Reference: Manston Green

Technical note

Re: Manston DCO Application – Noise Comments

Figure 12.6
Aircraft noise - daytime $L_{Aeq,16hr}$
contours - year of forecast maximum
capacity

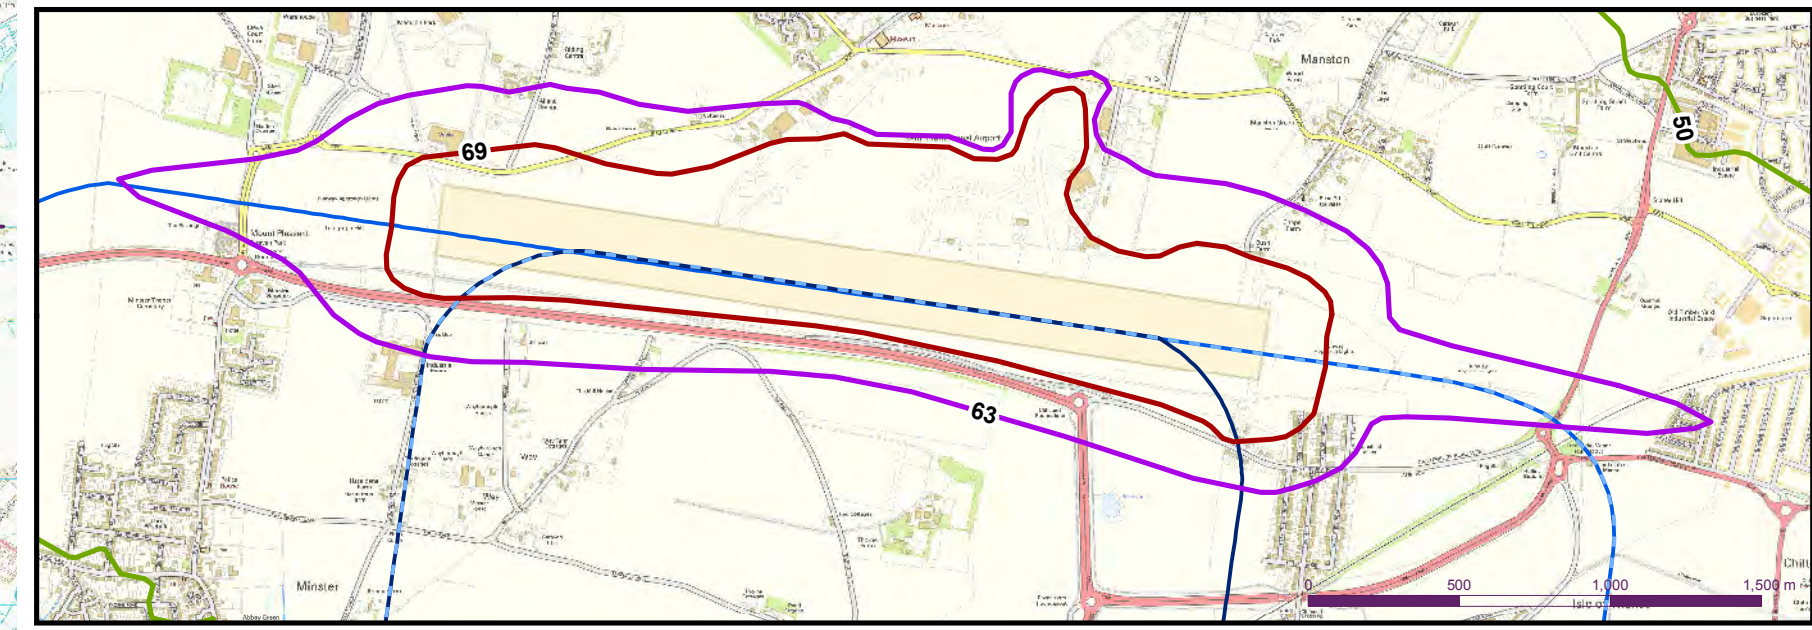
- 3.6 There is no reference to the approved Manston Green masterplan layout in the noise models. Without this level of detail it is not possible to carry out a detailed assessment of the impact on the Manston Green Development. In addition as different criteria have been used it is not possible to carry out a direct comparison to assessment levels against those upon which the Manston Green development was designed.

- 3.11 The second restriction on the site, Condition 35, requires that guidelines levels in BS 8233: 1999 are met. As there is no model showing the 57 dB daytime contour it is not possible to determine whether the DCO application would result in more properties requiring specific noise insulation work to achieve internal noise levels within the requirements of BS 8233: 1999. This information is required to determine whether the DCO application may cause restrictions on the development of Manston Green.

- 3.13 It not possible to accurately predict the impact of more than double the increase in ATM's using the information within the DCO application as this would depend on the type of aircraft and flight path. However, if we were to assume a similar mix as used in the noise models, a simple threefold increase in aircraft, could result in overall noise levels increasing by 5 dB. This would have an effect of adding 5 dB to the noise contours (i.e. the 63 dB contour would become 68 dB; the 50 dB contour would become 55 dB and so on.

- 3.14 The result of the above is that the 63 dB (lower limit of NEC C) contour could cross the area identified for residential development at Manston Green site resulting in a reduction in the area able to be developed for residential use and hinder the reserve matters application.

4.4 It is recommended therefore that further assessment if the impact of the DCO application on Manston Green is carried out. This should include the production of new acoustic models showing the daytime 57 dB contour for both the forecast years (Year 2 and Year 20) as identified in Chapter 12 of the ES and the production of a new model showing the predicted noise levels based on the maximum capacity as identified in NSIP justification.

Figure 12.7
Aircraft noise - night-time $L_{Aeq,8hr}$
contours - year of forecast maximum
capacity

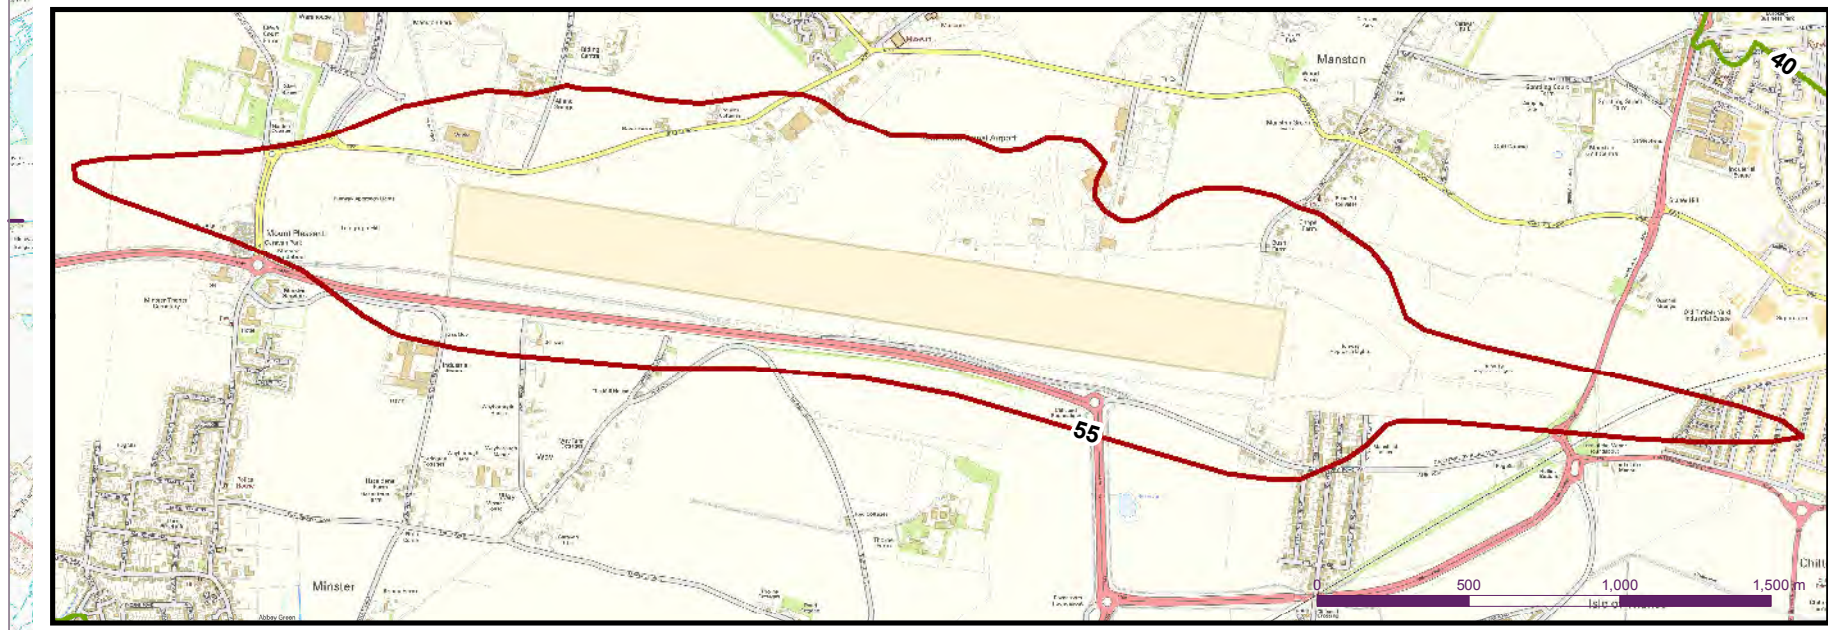
- 3.9 As shown in Figures 3 and 4 above, based on the illustrative Manston Green masterplan, no noise sensitive development would be within 63 dB $L_{Aeq16hr}$ or night time 57 dB L_{Aeq8hr} contours, as required by Condition 36. The proposed DCO application would therefore, not unduly restrict the area of Manston Green which is available for development, based on the assessment of the forecasted number of ATM's within Chapter 12 of the DCO ES as described in paragraph 3.5 above.

Figure 12.9
Aircraft noise - night-time L_{ASmax}
contours - year of forecast maximum
capacity

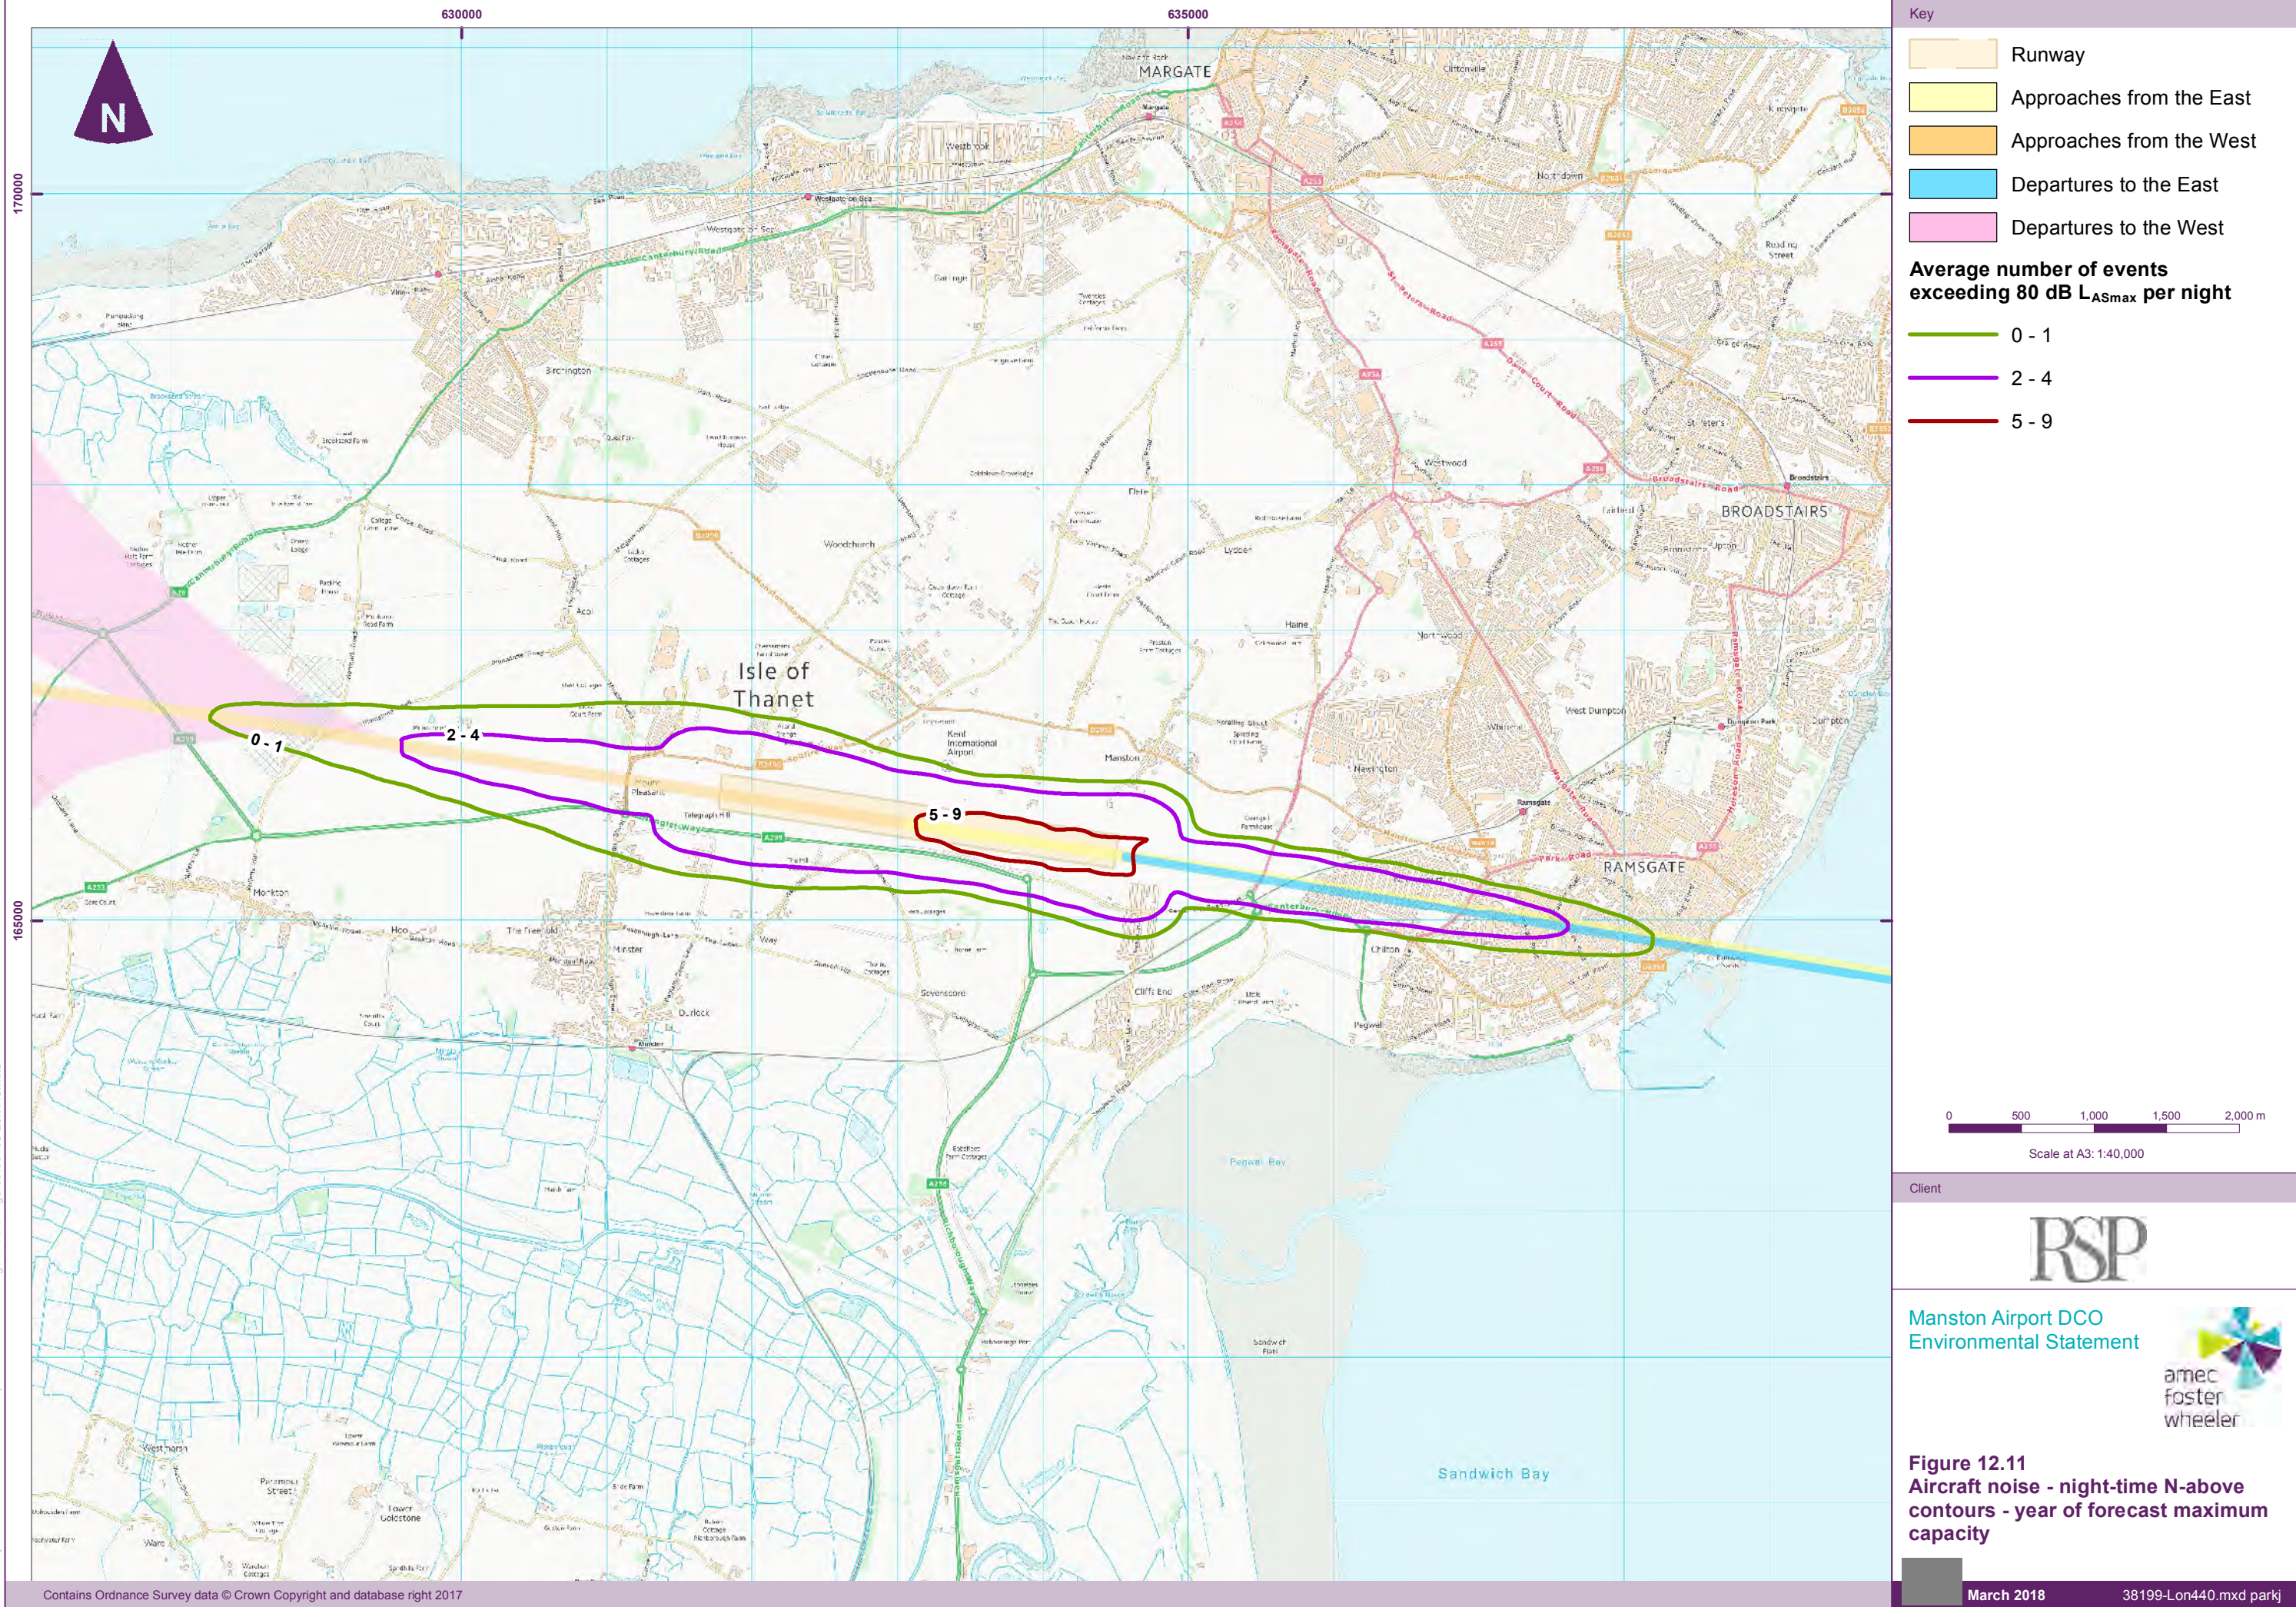
- 3.10 With regard to maximum noise levels at night, as shown in Figure 12.11 of the DCO application, the southern part of the site will be subject to events exceeding 80 dB L_{ASmax} , however due to the proposed night time restrictions the number of events is low between 1 – 4. This impact is similar to position assessed when outline consent was granted for the Manston Green site. In terms of maximum night time noise levels the DCO application does not result in any further restrictions on the site.
